We have also responded to the LLFA comments below in red.

Drawn By:	RS	Client	Markbank Construction Ltd.
Chkd By:	WRA	Project	Proposed Redevelopment, Morley Site, Arkwright Road, Bicester
Scale @A3:	1:500	Title	Impermeable Area Plan
Date:	08.07.2021		
Status:	TENDER		
Project No.:	23200	Drawing No:	E13
		Rev:	B

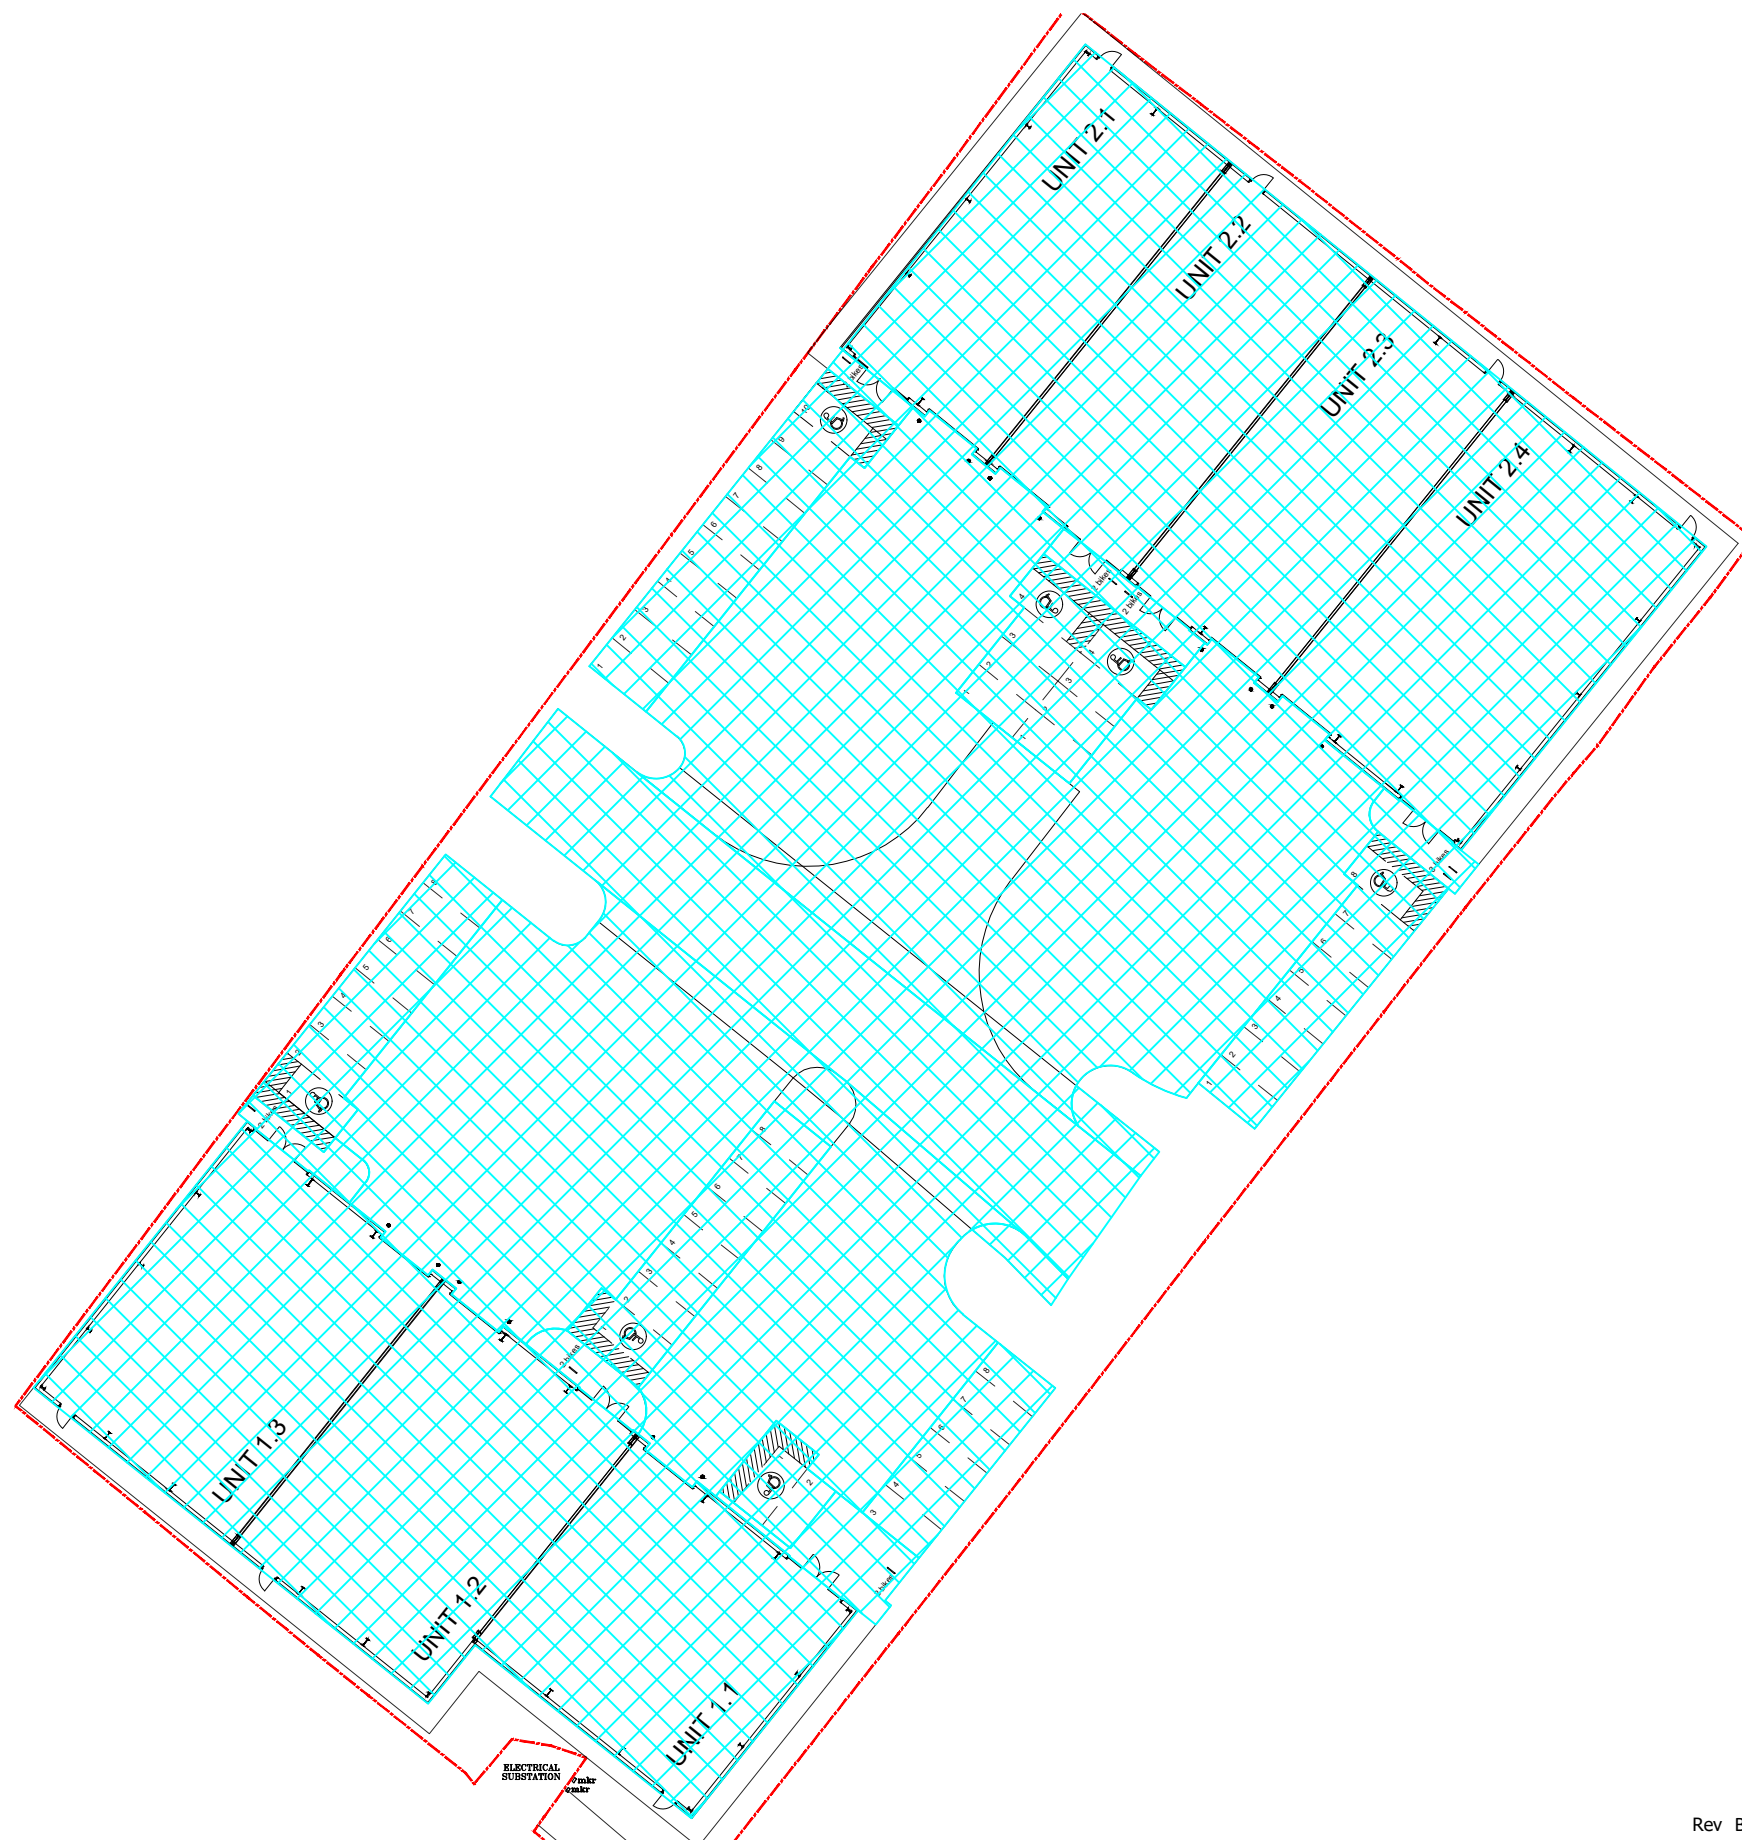
1. Insufficient details were provided to demonstrate the SuDS design for the proposed development. It is therefore not possible to undertake a technical assessment of the proposal and ascertain whether a sustainable surface water drainage strategy can be delivered on site. **SuDS will be used on site via tanked permeable paving for the car parking bays for proposed development. A bypass separator will also be used to ensure surface water is treated for the concrete yard.**

PERMEABLE BLOCK PAVED PRIVATE PARKING BAYS

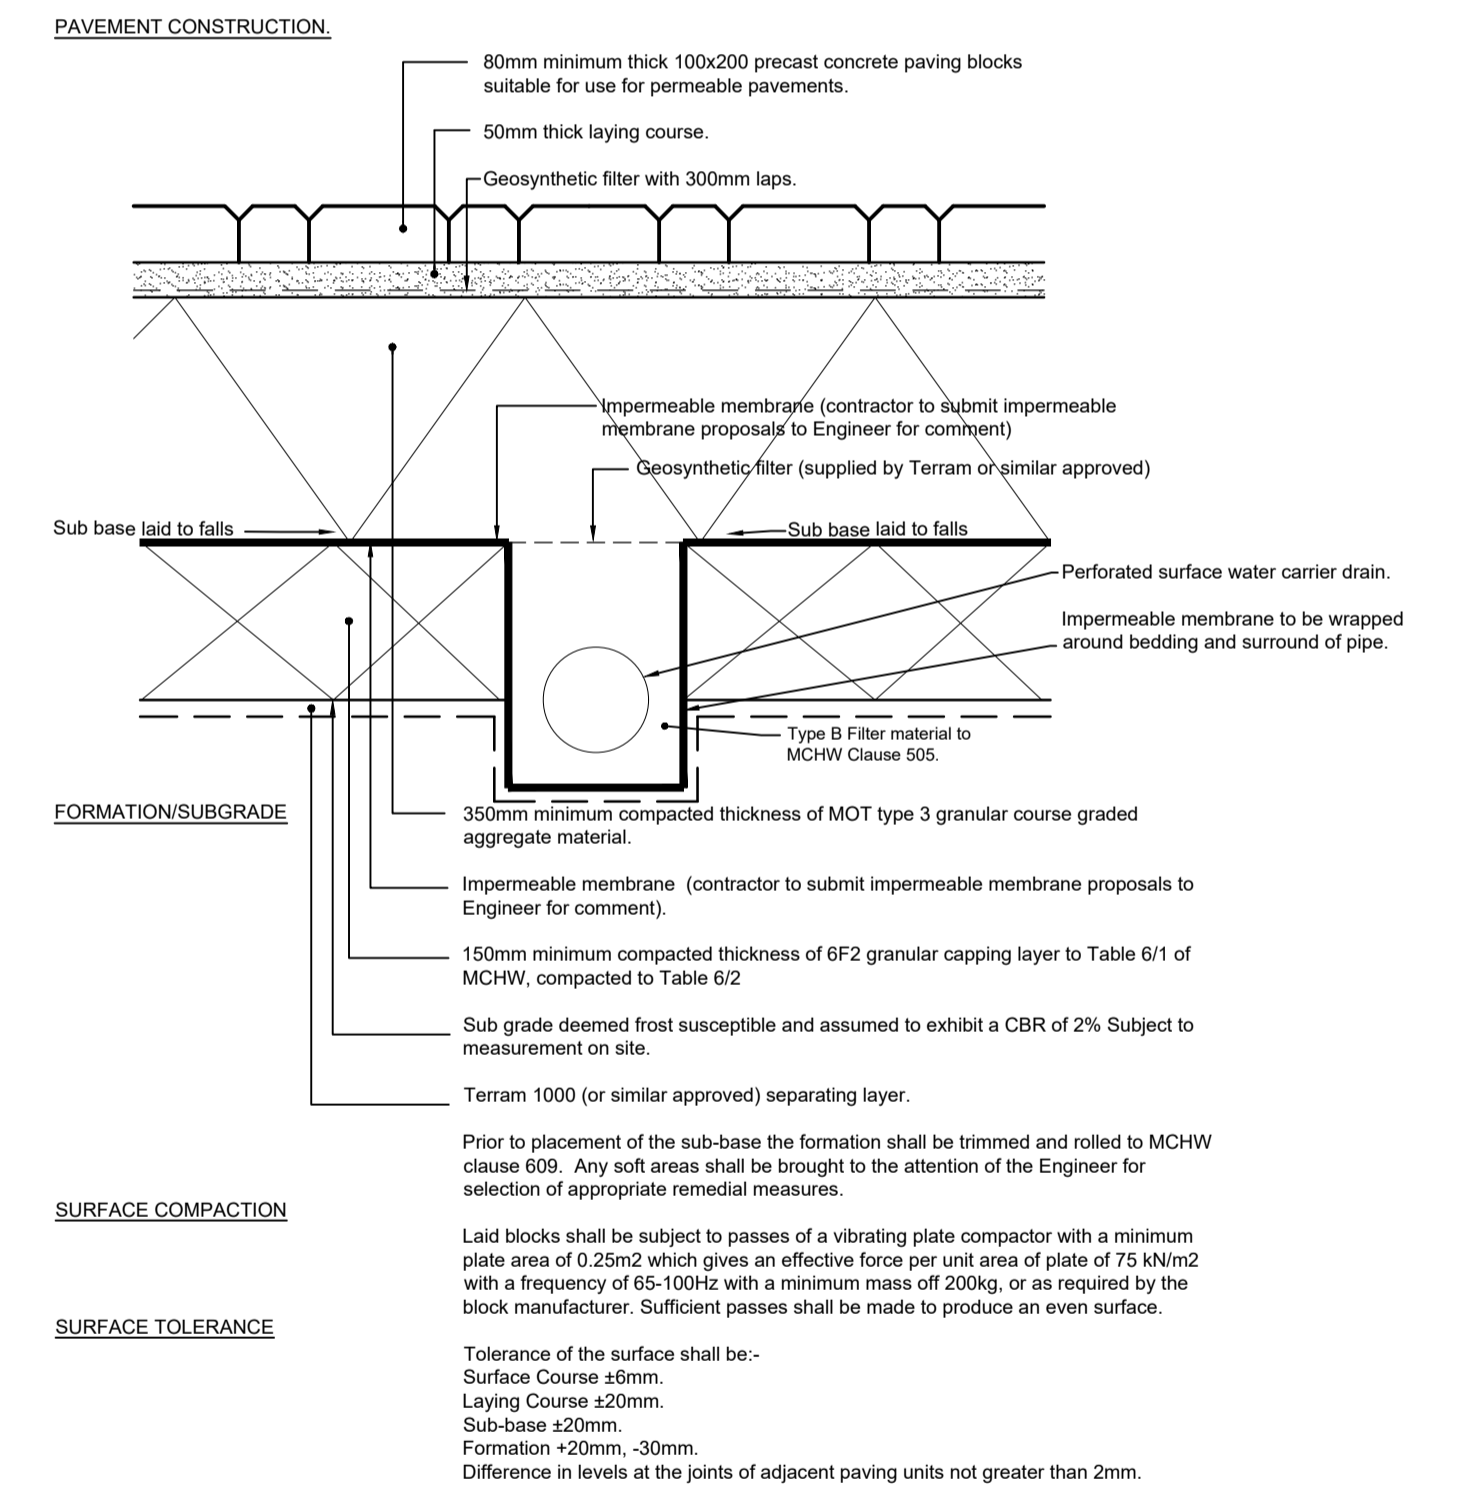
8. Proposed development must meet local standards, L19, "At least one surface feature should be deployed within the drainage system for water quality purposes, or more features for runoff which may contain higher levels of pollutants in accordance with the CIRIA SuDS Manual C753. Only if surface features are demonstrated as not viable, then approved proprietary engineered pollution control features such as vortex separators, serviceable/replaceable filter screens, or pollution interceptors may be used" **Tanked permeable paving will be used for car parking bays along with a bypass separator for the concrete yard to ensure storm water is treated adequately.**

<table><tr><td>Drawn By:</td><td>RS</td><td>Client:</td><td>Markbank Construction Ltd</td></tr><tr><td>Scale @ A0:</td><td>1:200</td><td>Title:</td><td>Proposed Drainage Layout</td></tr></table>

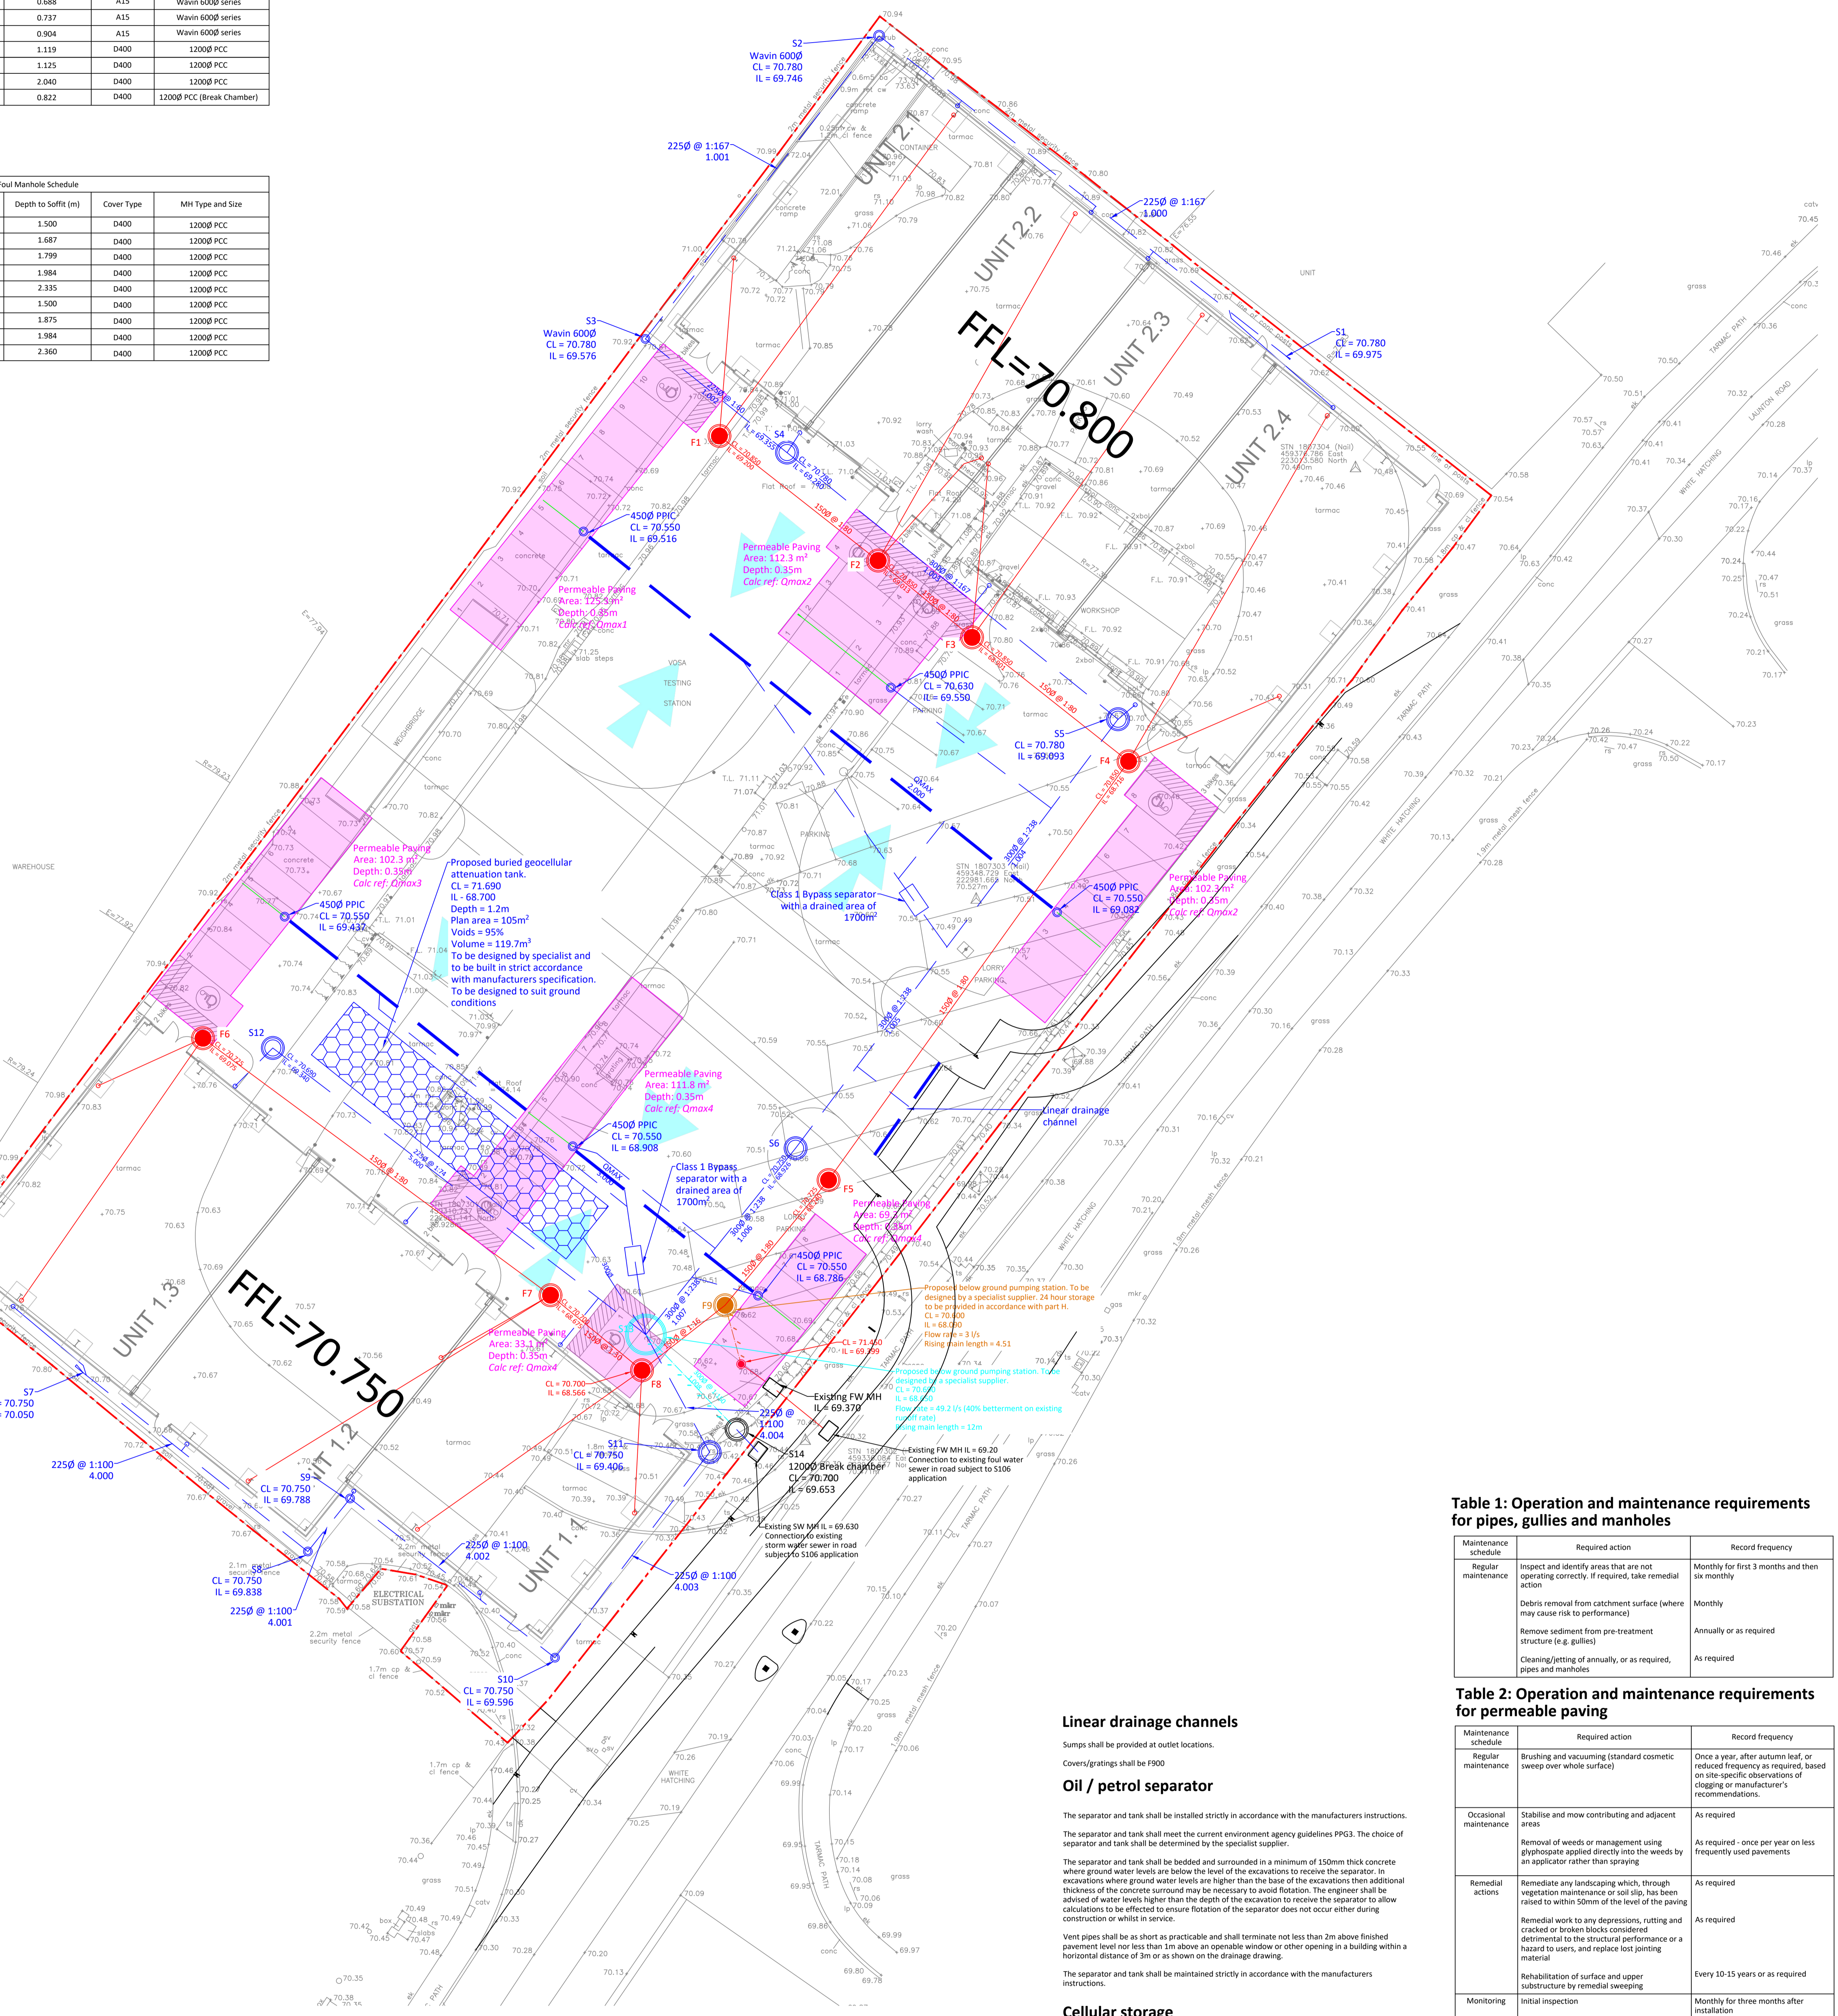
2. Insufficient information was provided in the Flood Exceedance Layout and surface water drainage layouts. **A flood exceedance plan has been provided. The drainage layout has now provided all relevant information.**

4. No details provided of the future maintenance and management of the site SuDS features. **A maintenance schedule has been provided on the drainage drawing.**
